Your Ref: OWPC17948
Our Ref: P/1/18/DOC 05-01-2018
Please ask for:
Mr S Davis

Application for approval of details reserved by conditions imposed under planning permission P/125/14/PL relating to condition No. 10 (Refuse & recycling bins), condition No.14 (Visitor Parking Spaces), condition No.15 (Surface water onto Highway), condition No. 16 (Street Lighting), condition No. 18 (Cycle Parking), condition No. 21 (Landscaping), condition No. 22 (Screen Walls & Fences) & condition No.26 (External Lighting), condition 31 (Dog Walking)
251 Pagham Road & Land R/O Pagham

P/1/18 Discharge of condition 21

drawing title	Landscape General Arrangement (East)				
drawing no.	1896-TF-00-00-DR-L-1002				P03
scale	1:250 @ A1	date	28.09.17	drawn by	AC
				checked by	AC

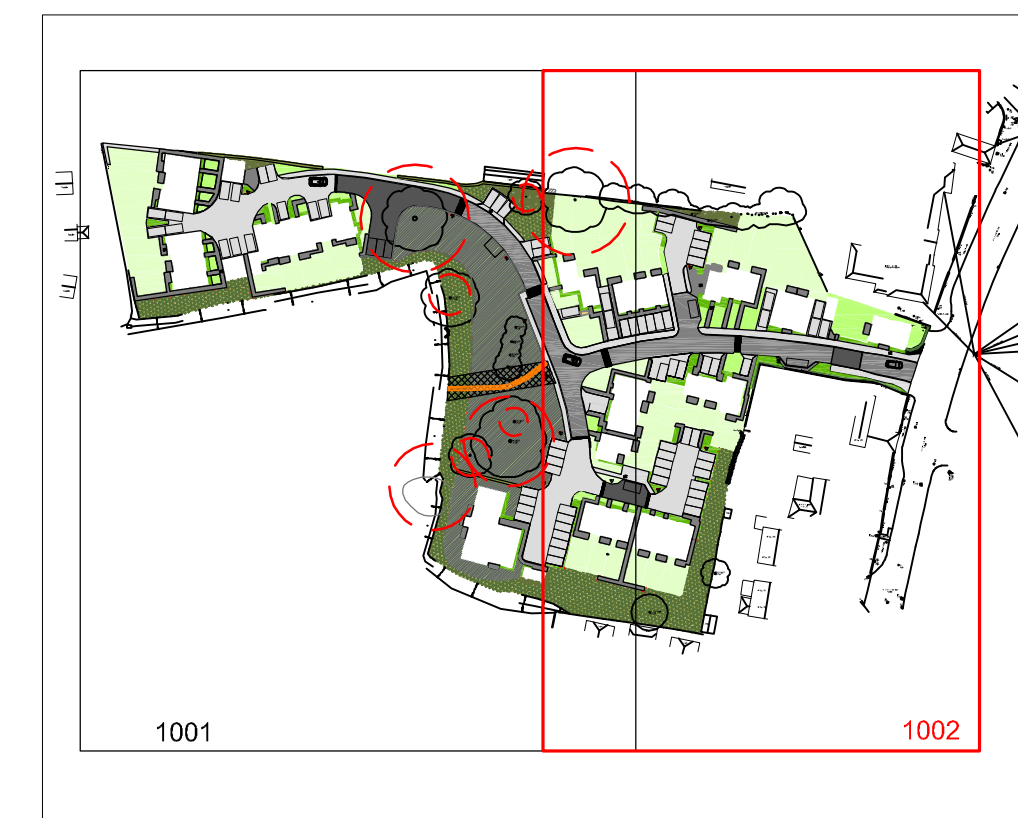
i) The trees proposed are deciduous trees which will mean that when the leaves drop the new development will be fully visible to the existing properties in Pagham Road. The visual barrier cannot therefore be considered appropriate unless tall evergreens are introduced or the tree planting is significantly increased.

ii) It would appear that there is no plan submitted for the maintenance of these areas and much of the planting proposals are ephemeral. What is the plan for future replacements maintenance and who will be responsible?

iii) It is also not clear on the maturity/height of the initial planting as this would have significant implications to the initial visual screening from year 1.
